<b>Consultation Response from KC, Highways Development Management</b>
<b>2024/90548 Former Riverside Works, Honley, Holmfirth, HD9 6PW</b>
<b>Erection of veterinary surgery (Use Class E) and associated works including the formation car parking and landscaping</b>
<b>Date Responded: 15/11/24 Responding Officer: CNB Responding Ref: K3-49/2</b>

**Figure 19:**  
Diagram; Vehicular Access

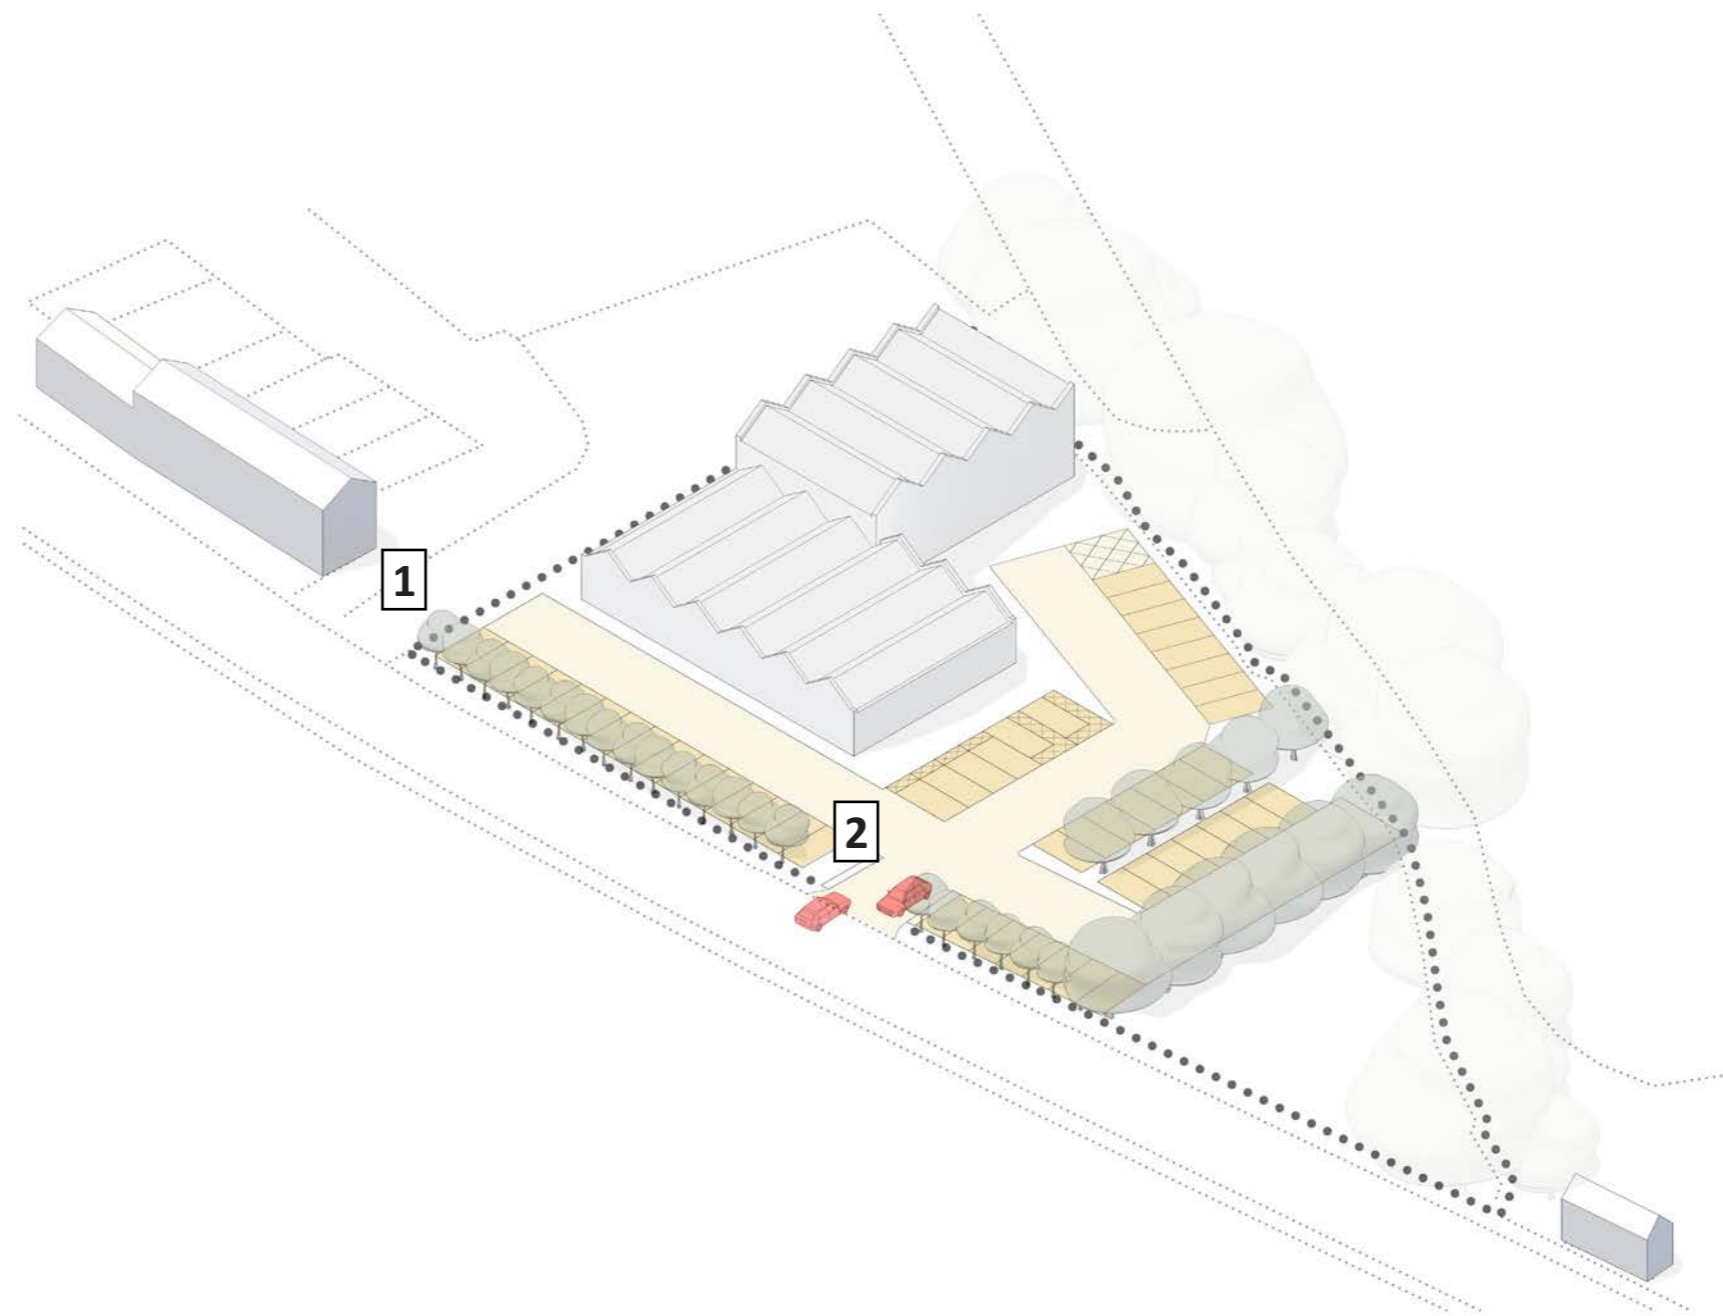
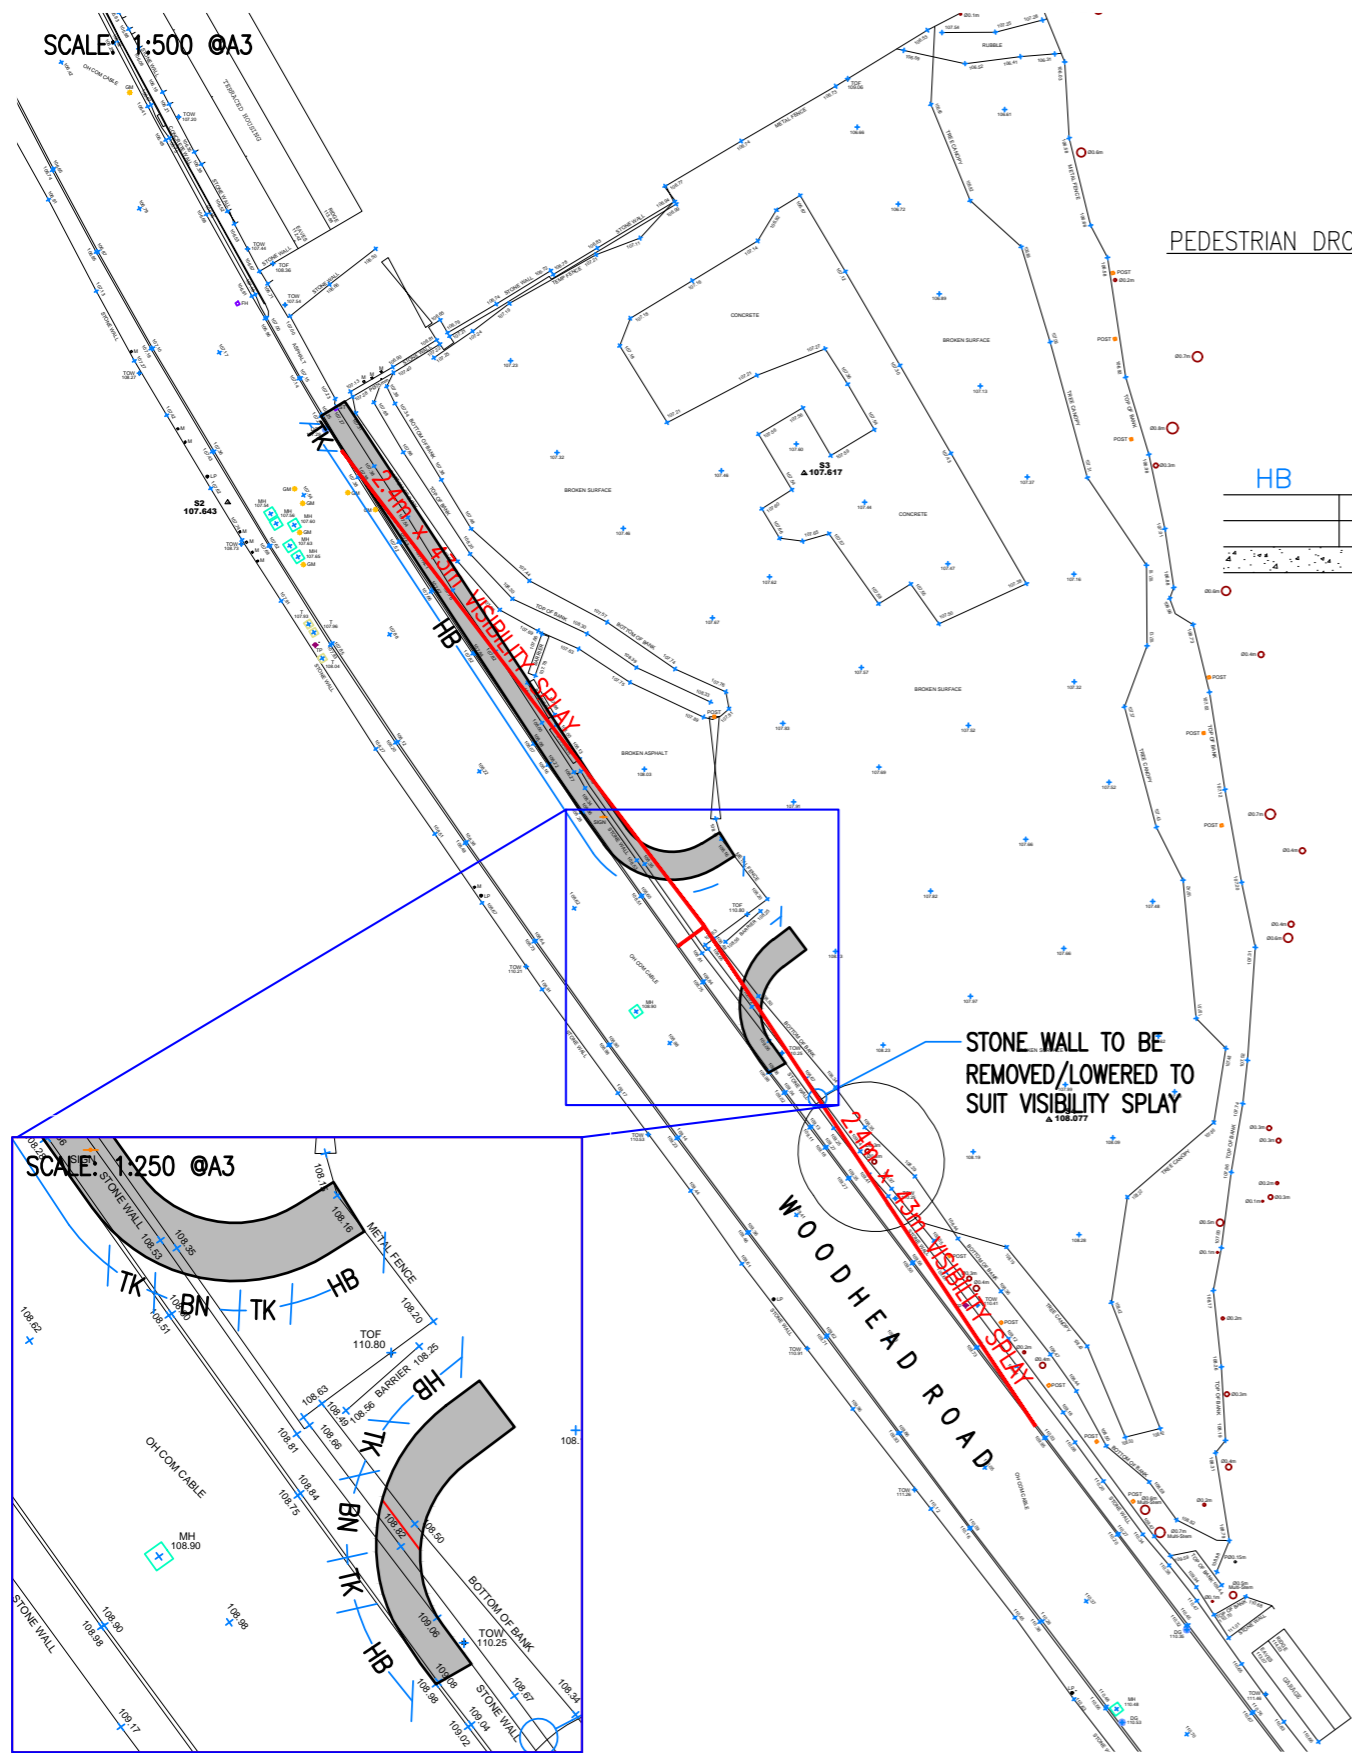
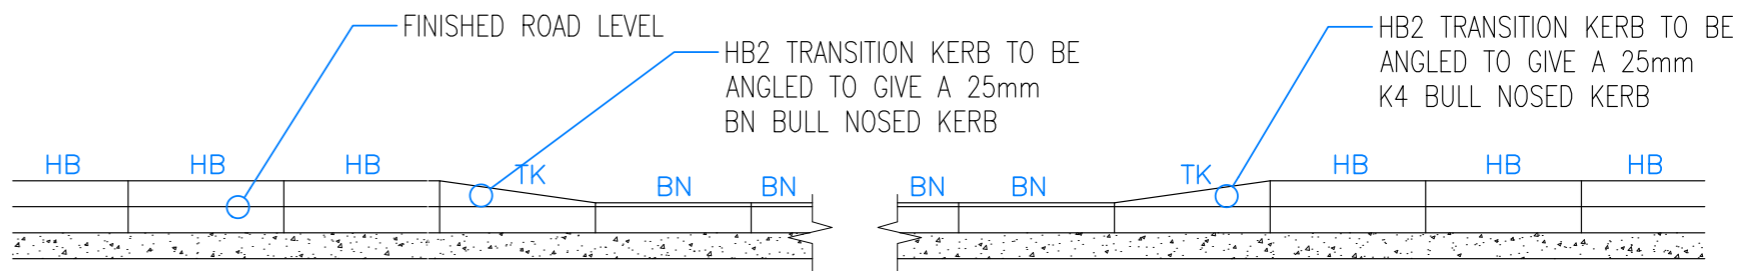
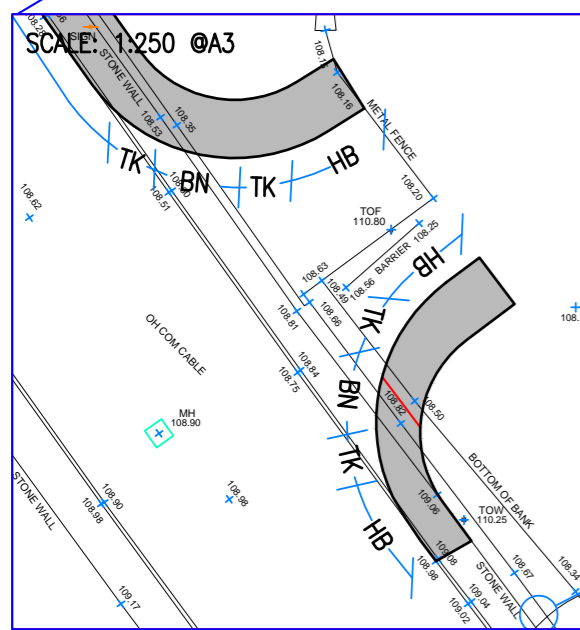
The Transport Statement indicates that the pedestrian footway to the north-west of the proposed access will be improved to 2m width for approximately 45m, this is shown on drawing No 2403001 as a preliminary drawing. Detailed designs will be required and this work should be done within a s278 agreement with the LHA. The works on the highway will need to be included within a stage 1 Road Safety Audit, details of RSA requirements are provided below.

There is currently a dropped kerb crossing access in to the site and this was used by the previous occupants of the site for their plant hire business. The proposals are to add a new standard kerbed access to the south east and the Transport Statement states that the existing dropped kerb will be removed with a new kerbed footway provided. This can be conditioned.

The proposals to the new access will need a detailed design and should have a minimum radius of 6m. The access is shown at 6.5m width on drawing No 104 Rev 2 and this would allow two cars to easily pass. There will be a 2m footway extending in to the site on either side of the access

We would like to see a swept path analysis that shows the access can be safely used by a refuse vehicle of 11.85m length and this analysis should also be used to inform the required radius of the access for detailed design.

Drawing No 104 Rev 2 shows a visibility splay of 2.4m x 45m at the access and this would be suitable for an 85<sup>th</sup> percentile speed of 30mph, however there are concerns that the speeds along this section of A6024 may exceed the posted speed and so we would like to see a speed survey carried out to each side of the proposed new access in order to obtain an observed 85<sup>th</sup> percentile speed in order to produce a

visibility splay Y-length that represents this speed. The brief for the speed survey should be agreed with the LPA prior to commencement.

The Transport Statement indicates that the wall along the frontage of the site would be lowered to 1m to allow for the visibility splay to the left.

**Figure 21:**  
Diagram; Parking Provision

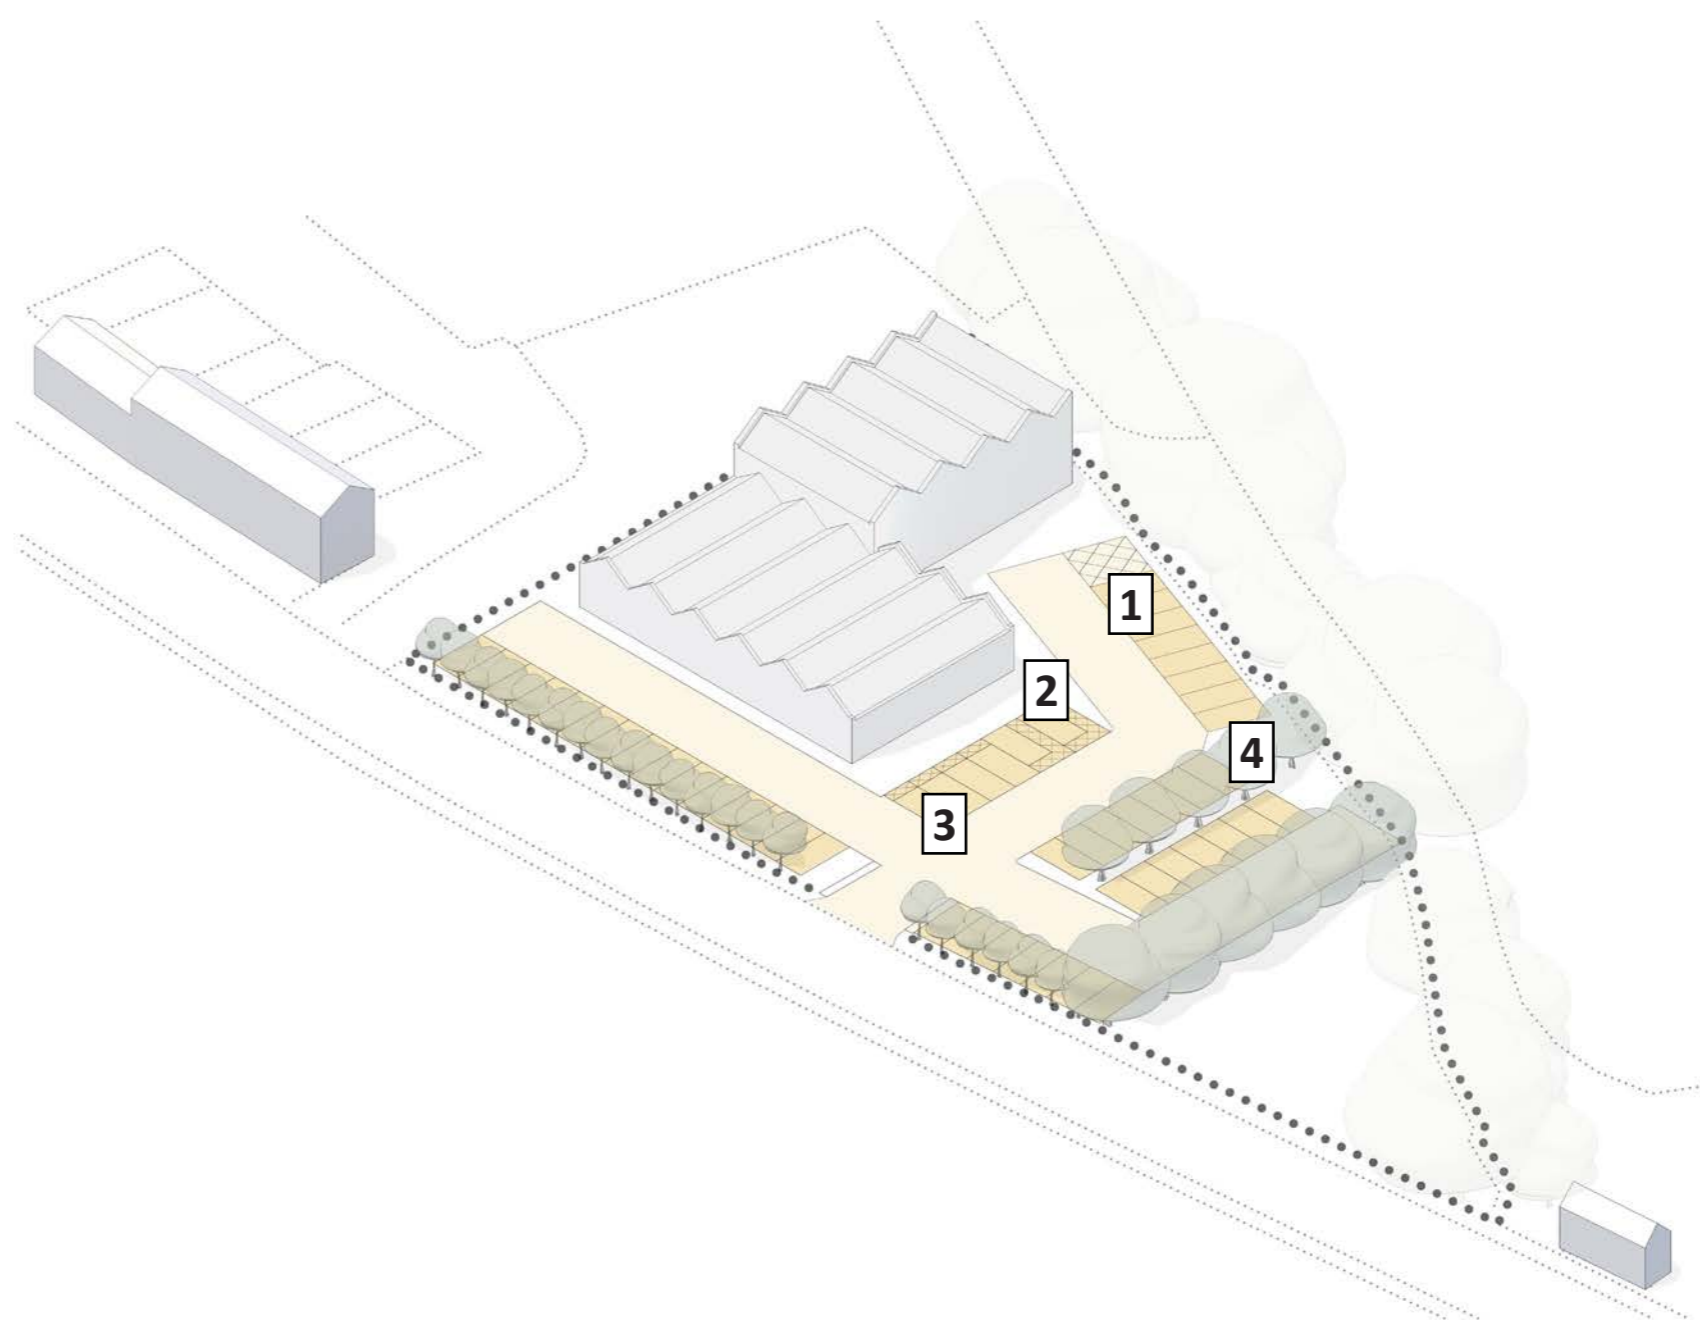
A car parking layout is shown in drawing No 104 Rev 2 and this consists of 50 car parking spaces. These are shown as being 2.4m x 4.8m and are acceptable at this size. There are two accessible spaces shown and three/four EV parking spaces. The access roads through the car park have a headway of 6m and this should allow easy and safe access to the parking spaces. It is noted that spaces No 1 and 43 may have a higher level of difficulty to access/egress and may be viewed as less desirable by visitors. However it is noted that the headway opposite space No 43 is 6.5m which may make manoeuvring slightly easier.

Cycle Parking is shown on Drawing No 104 Rev 2 as a covered/secure shelter for approximately 10 cycles located within the car park. We do not consider that this is a suitable location for cycle storage as it is away from main pedestrian movements and is not overlooked. We consider that it would be better to move the cycle parking shelter to a more prominent position adjacent to the main entrance. This would increase visibility of the cycle parking which would increase security and promote sustainable and active travel.

**Figure 22:**  
Diagram; Refuse Vehicle Access

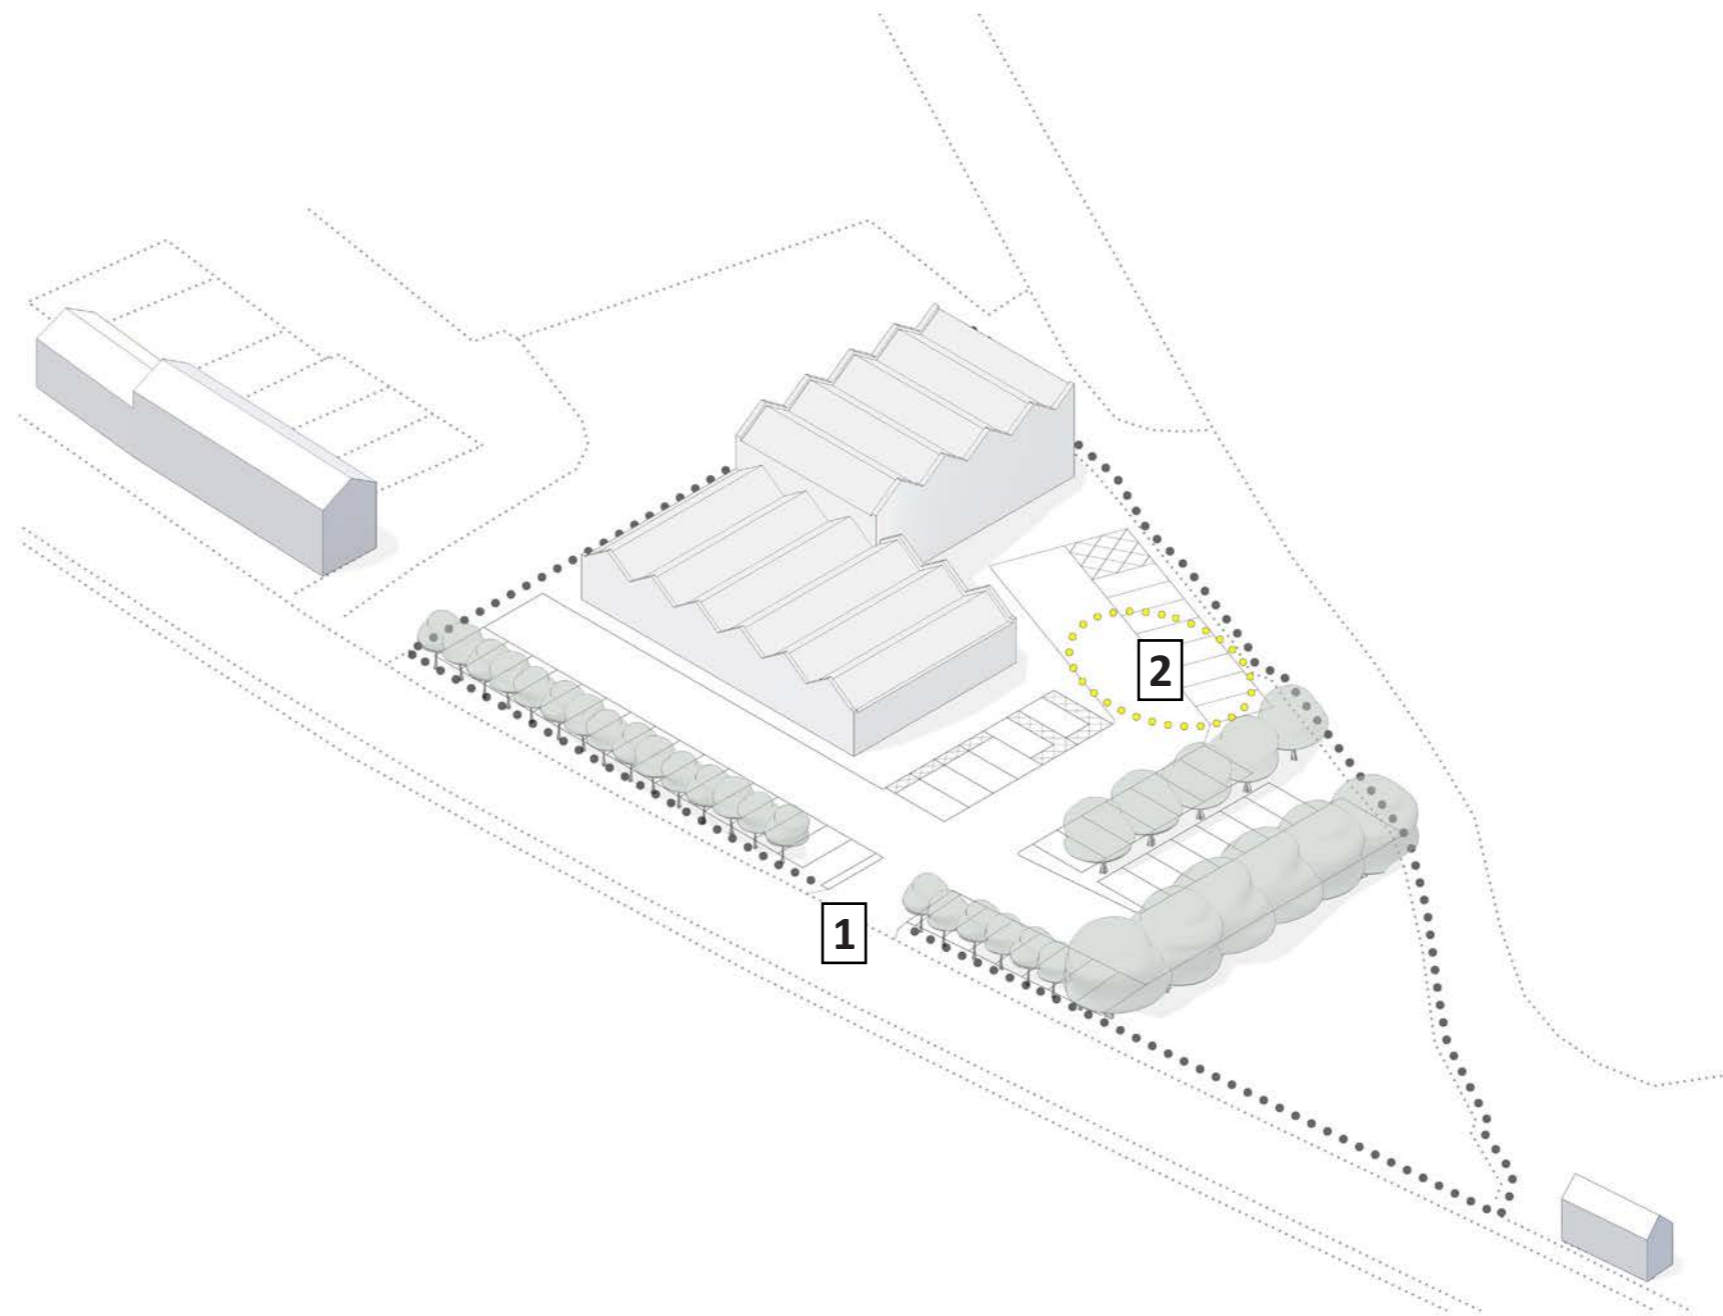
The internal layout will need to indicate the location of waste bin storage and how collection is expected to occur, including a bin collection presentation point and a swept path indicating that an 11.85m refuse truck can safely access the collection point and turn on site so that the vehicle can enter and exit the site in forward gear.
